**ADC Planning Consultation  
Conservation/Design Officer Response**

| <b>Application Number</b> | EG/78/17/L                                                                       |
| <b>Address</b>            | The Thimbles 80 Barnham Road Barnham PO22 0ES                                    |
| <b>Description</b>        | Application for listed building consent for replacement of existing thatch roof. |

Project & Drawing title				
Site location and Roof plan				
Drawn	Date	Checked	Date	Scale at A3
HG	02.11.17			1:500/ 1:100
Job N°	17-197	Drawing N°	001	Rev. A
Status	Planning Application

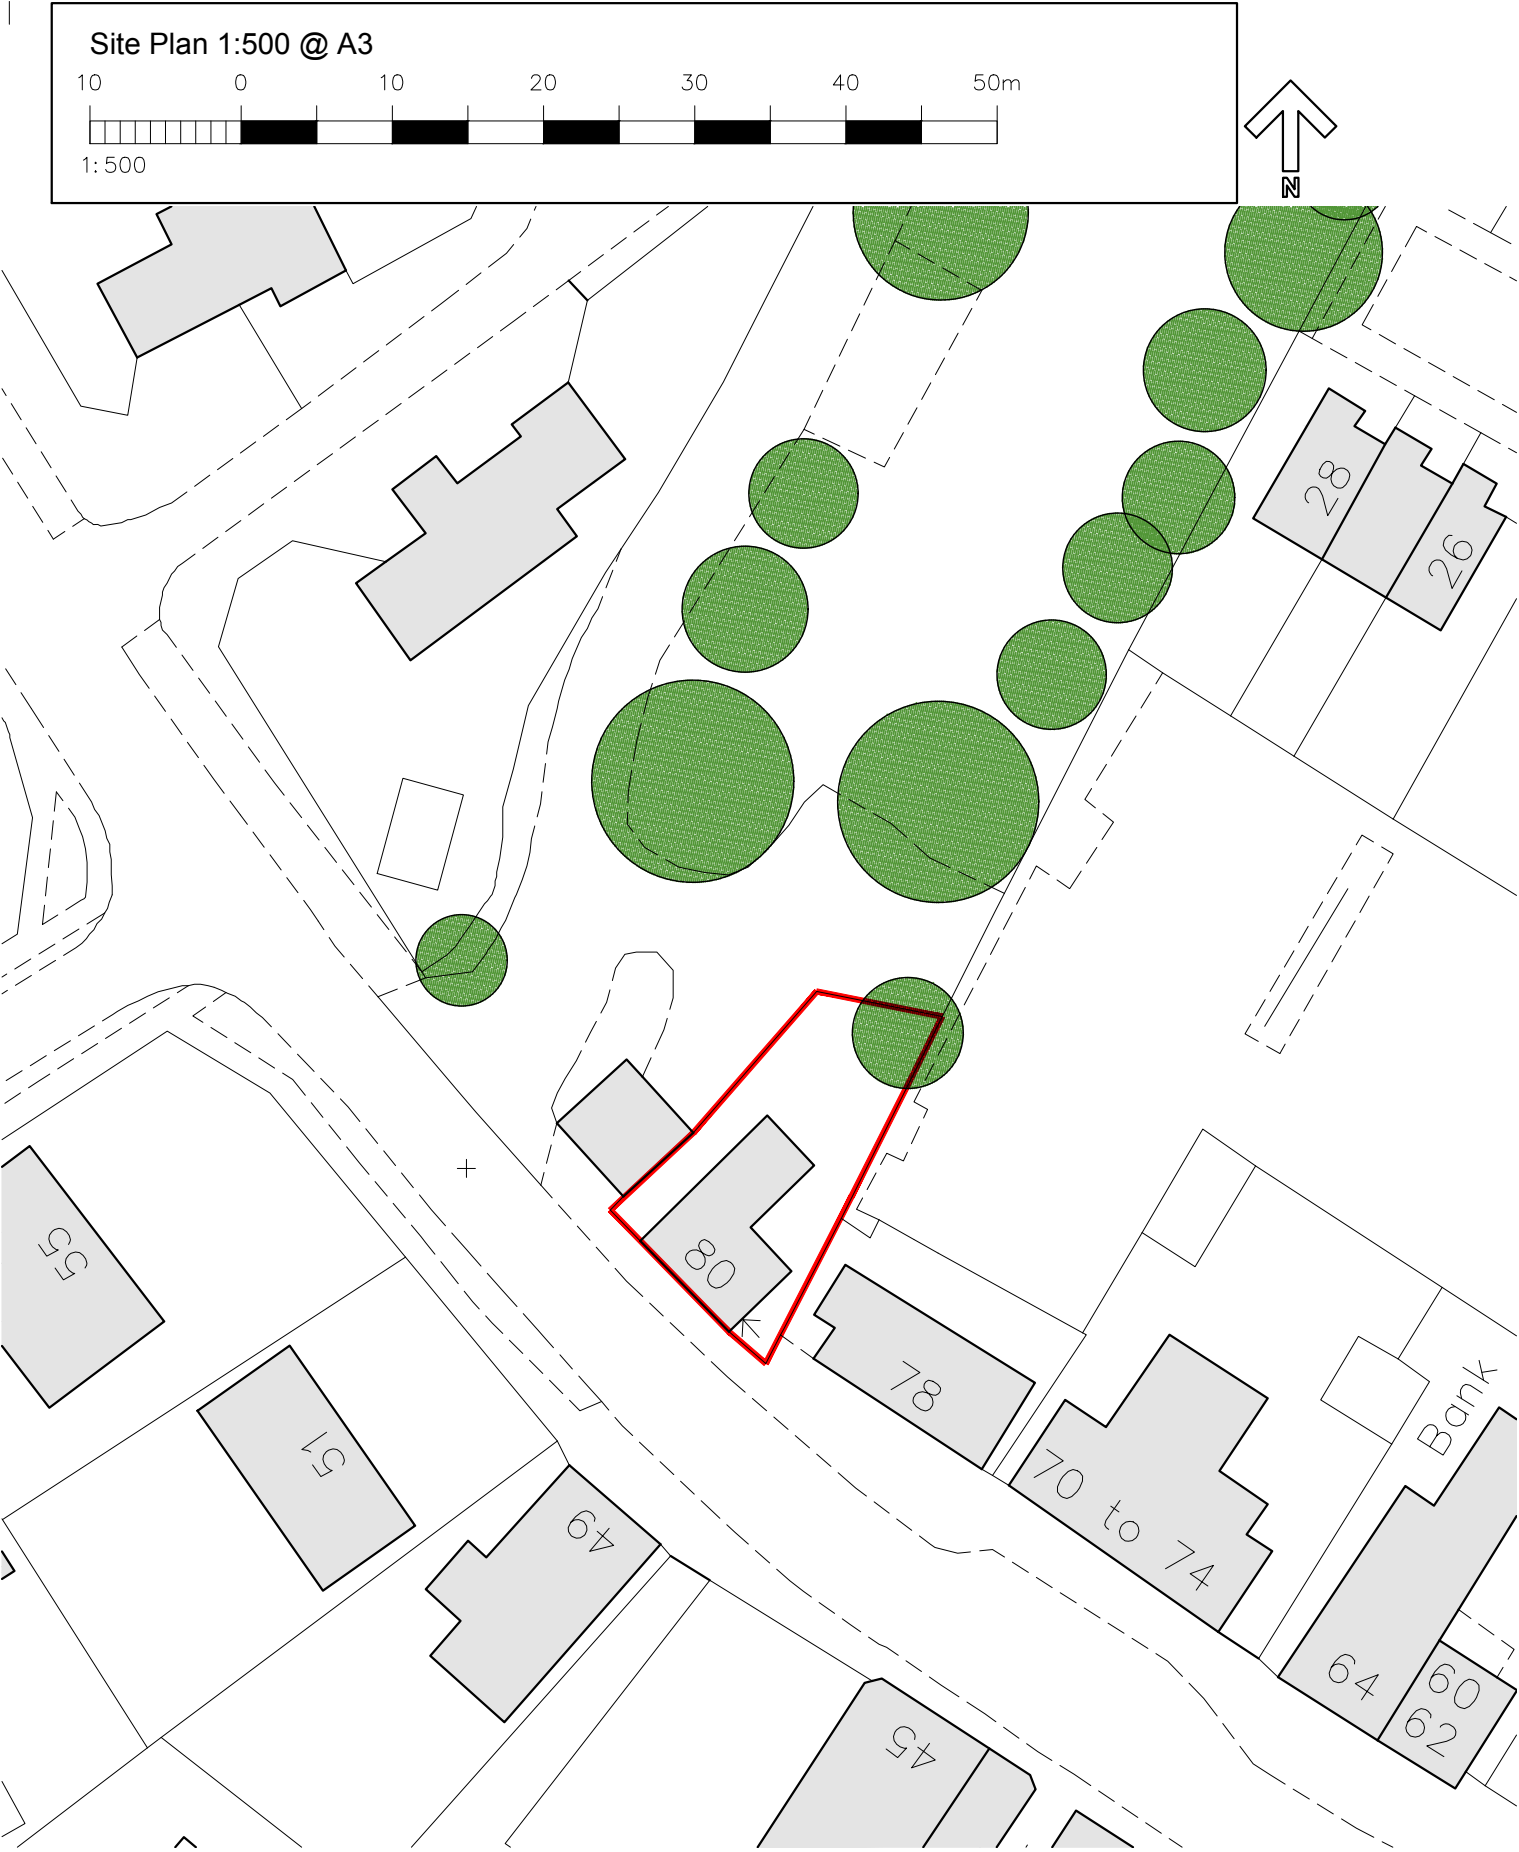
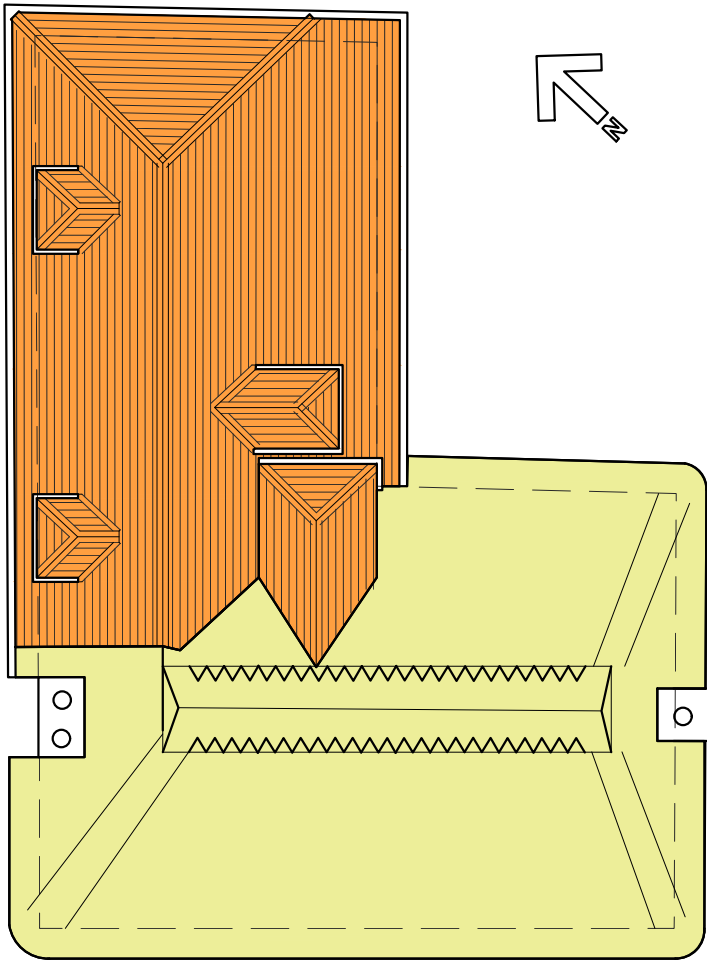
The proposal is to replace a thatched roof. While the photographic evidence supplied and the listing of a Master Thatcher in the applicants choice of craftsman, there is no detail of the type of thatch to be used.

It is recommended that the profile of the roof line, overall depth of thatch, dressing and ridge detail (currently a pheasant?), be like-for-like, unless advised otherwise. In any event the type of reed should be established, and works carried out by a suitably qualified craftsperson.
